December 14, 2023

**Re: Love's Sunport Station
3200 Broadway Blvd. SE
Conceptual Traffic Circulation Layout for DFT Approval
Engineer's Stamp 12-06-23 (M14-D038A)**

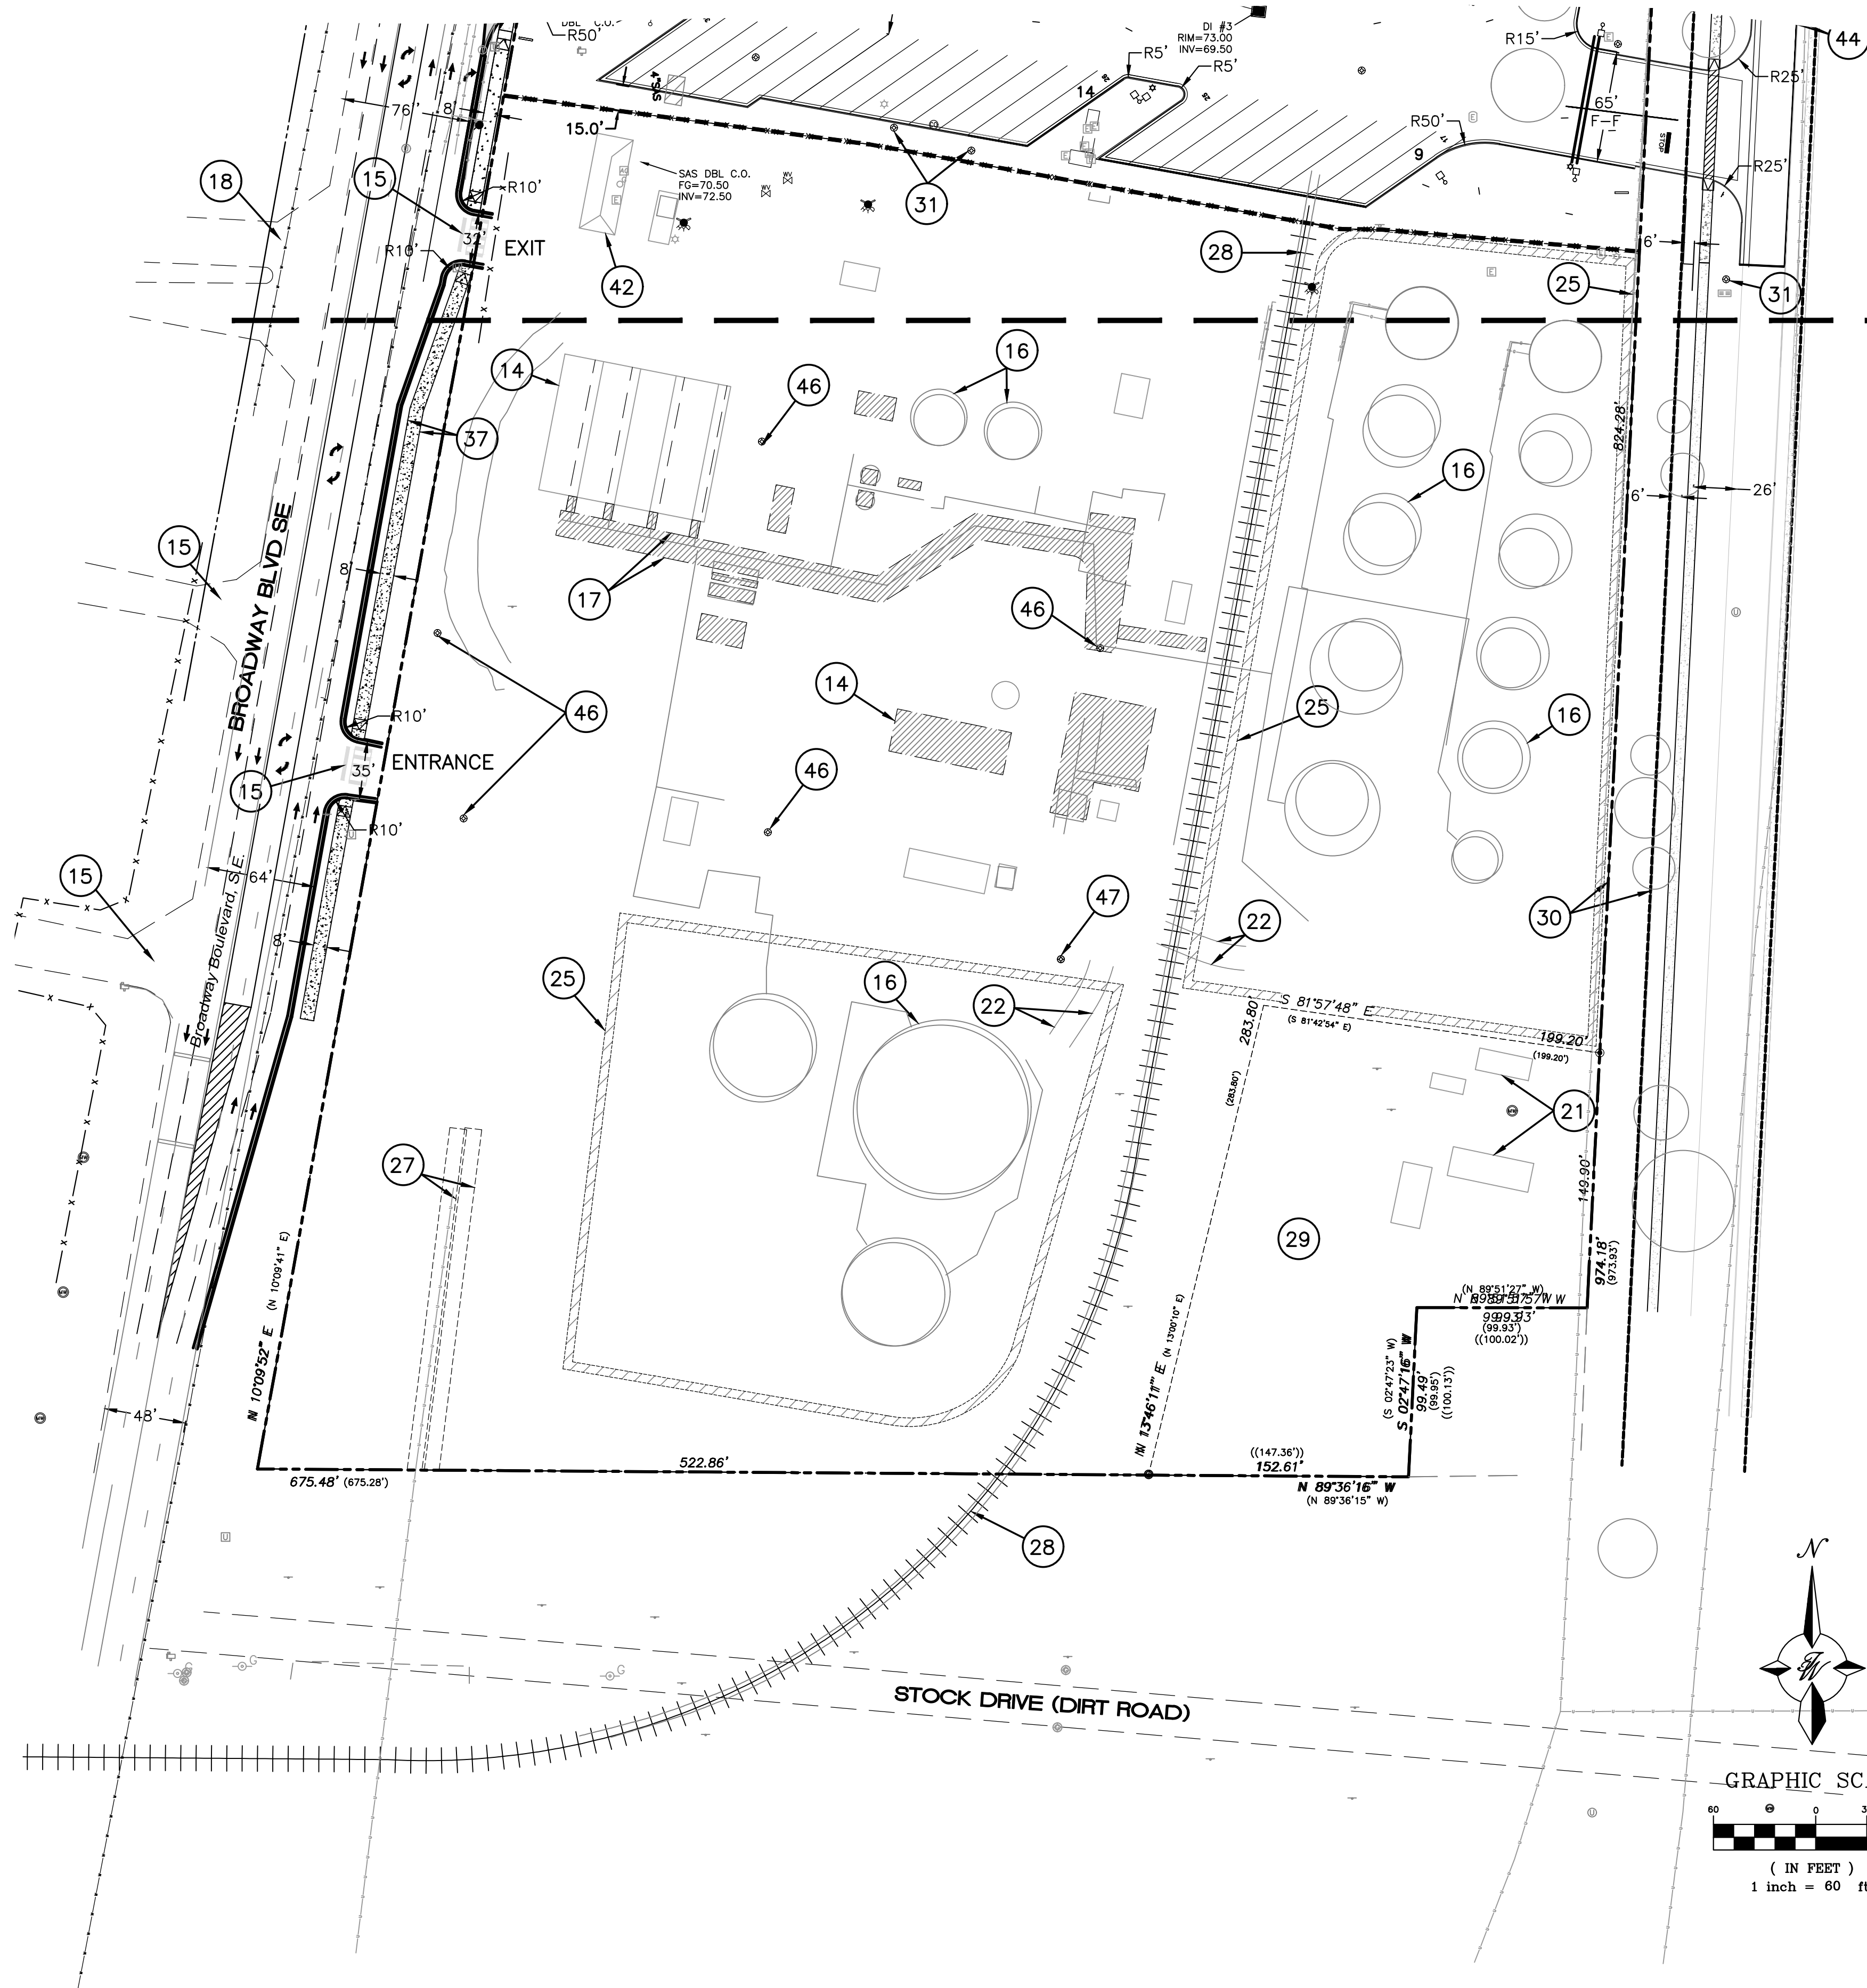
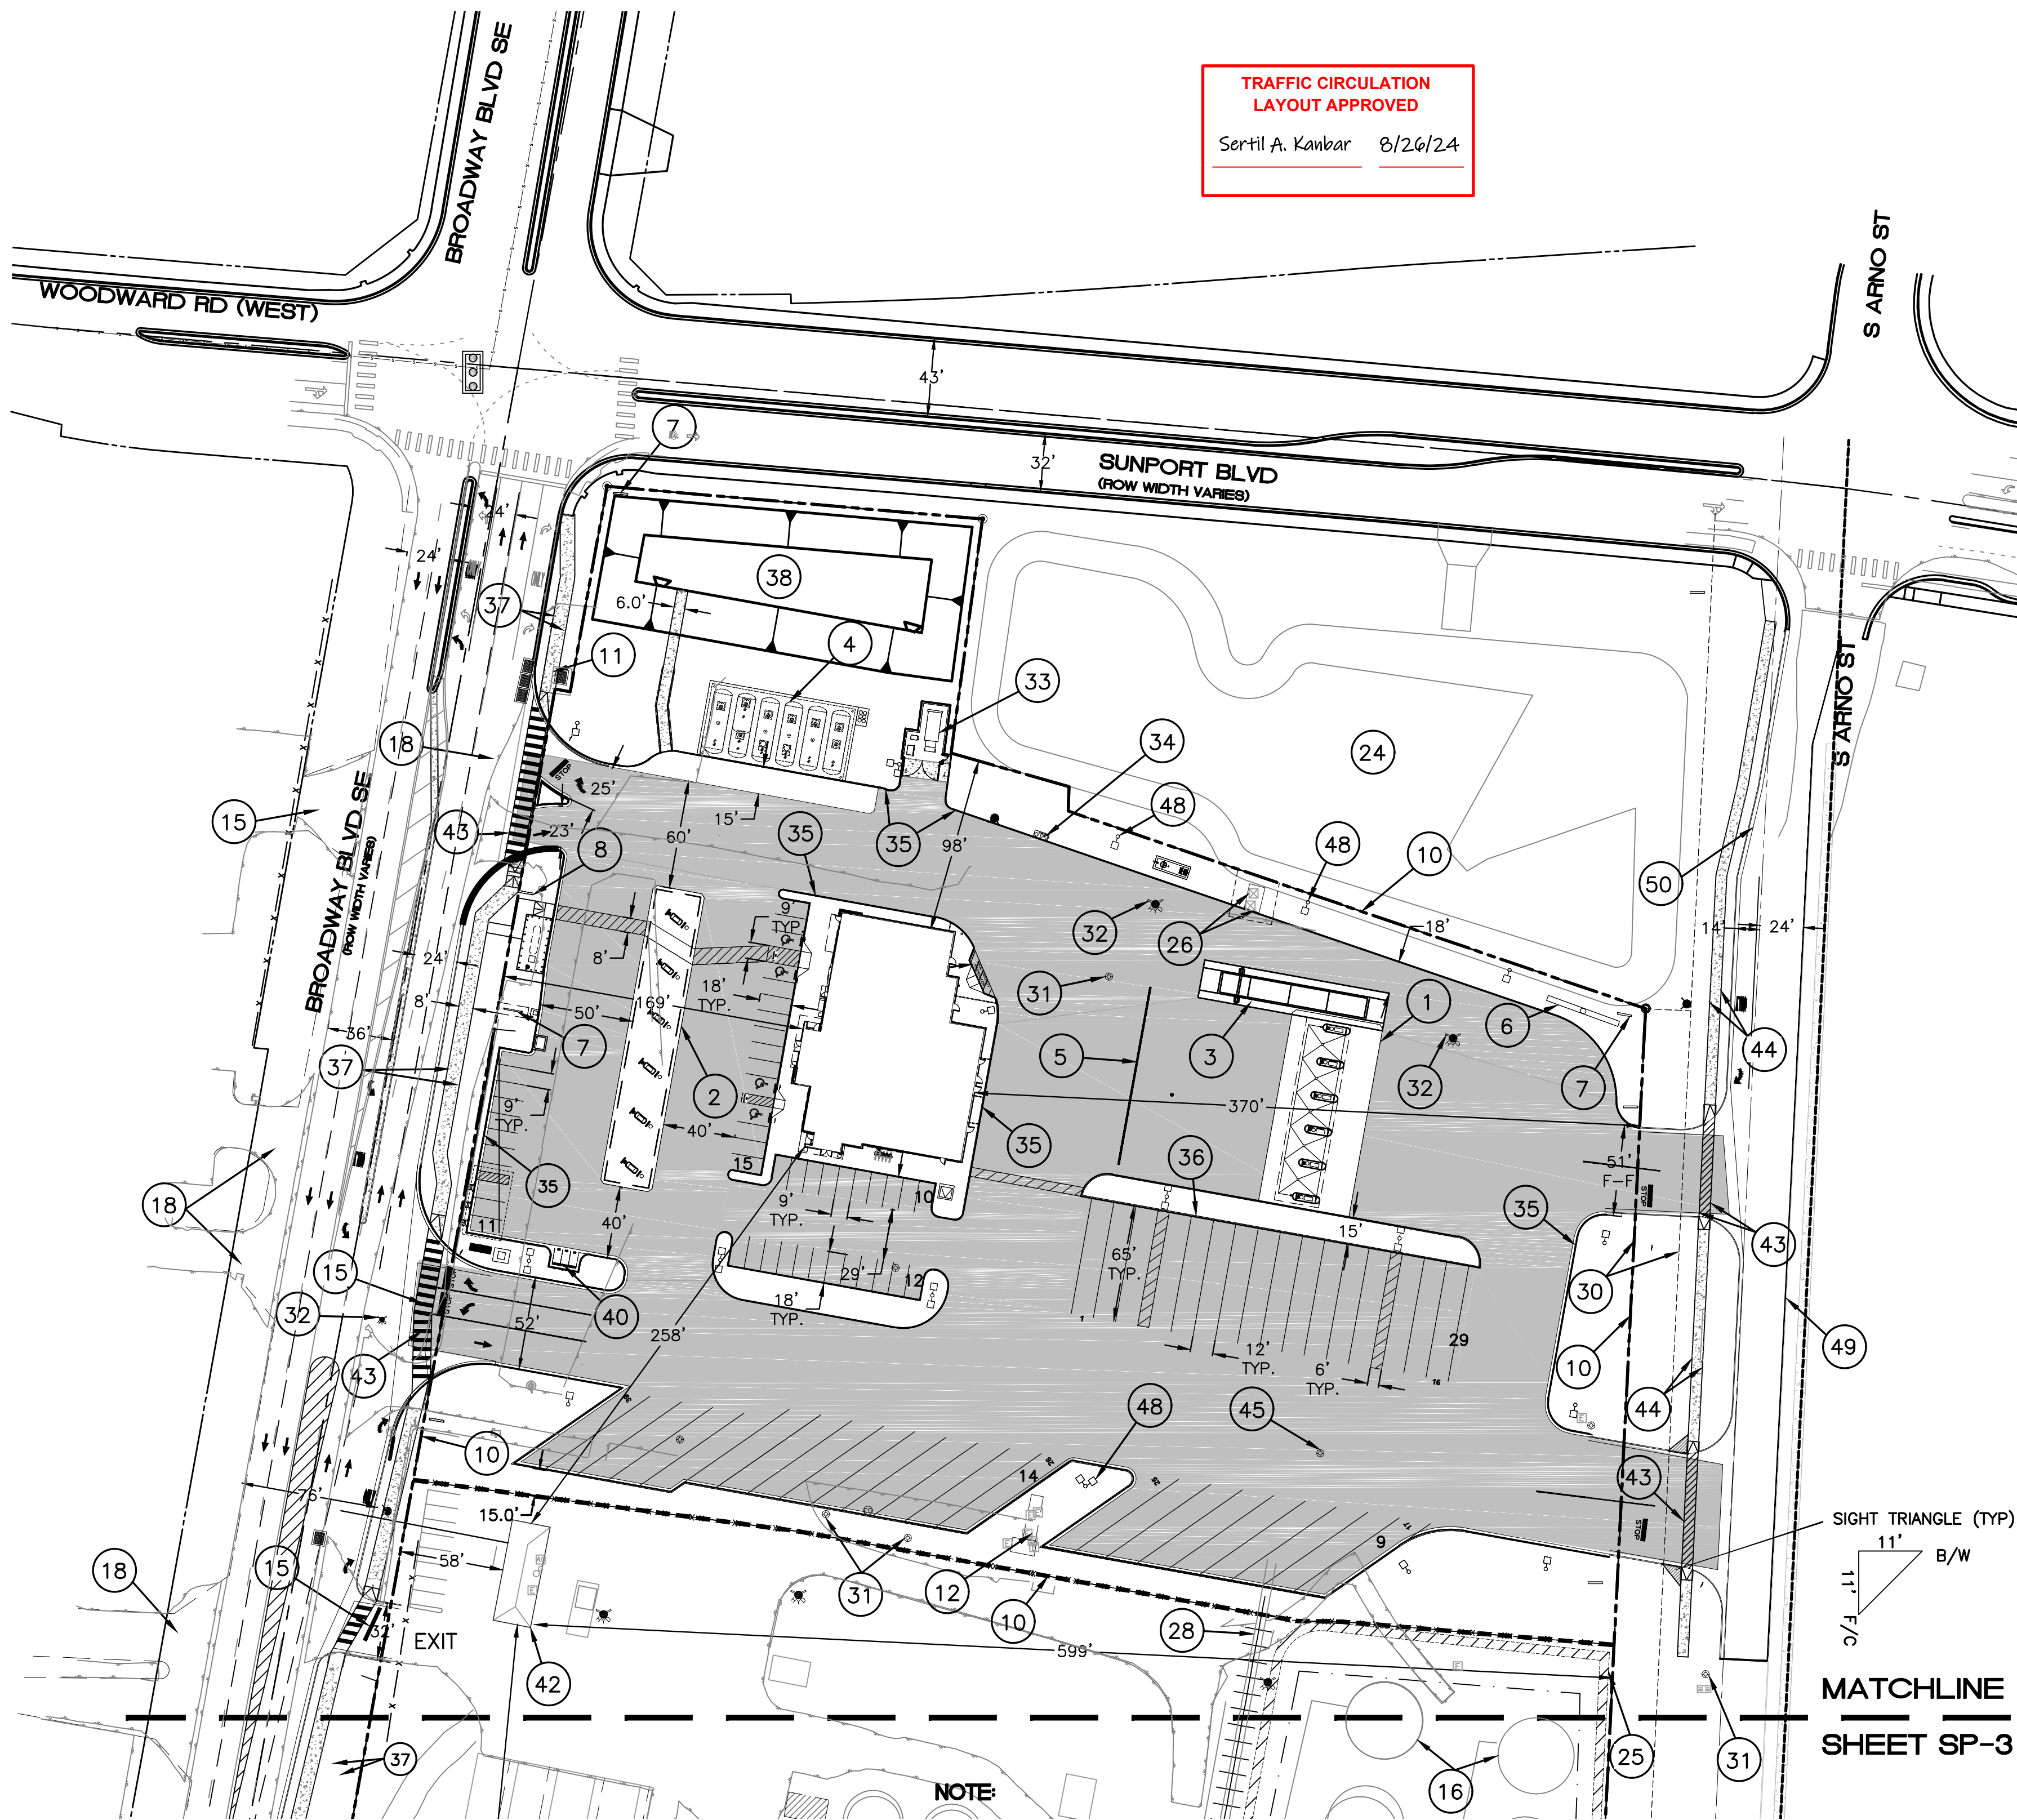
The conceptual TCL submittal received 11-09-2023 is approved for DHO and/or DFT submittal. When submitting this project through the building permit process, a full Traffic Circulation Layout will need to be submitted and approved prior to building permit. **When you submit TCL for building permit approval, please provide the following: 8 bicycle parking spaces, and show the clear intersection sight distance at the south east site access.**
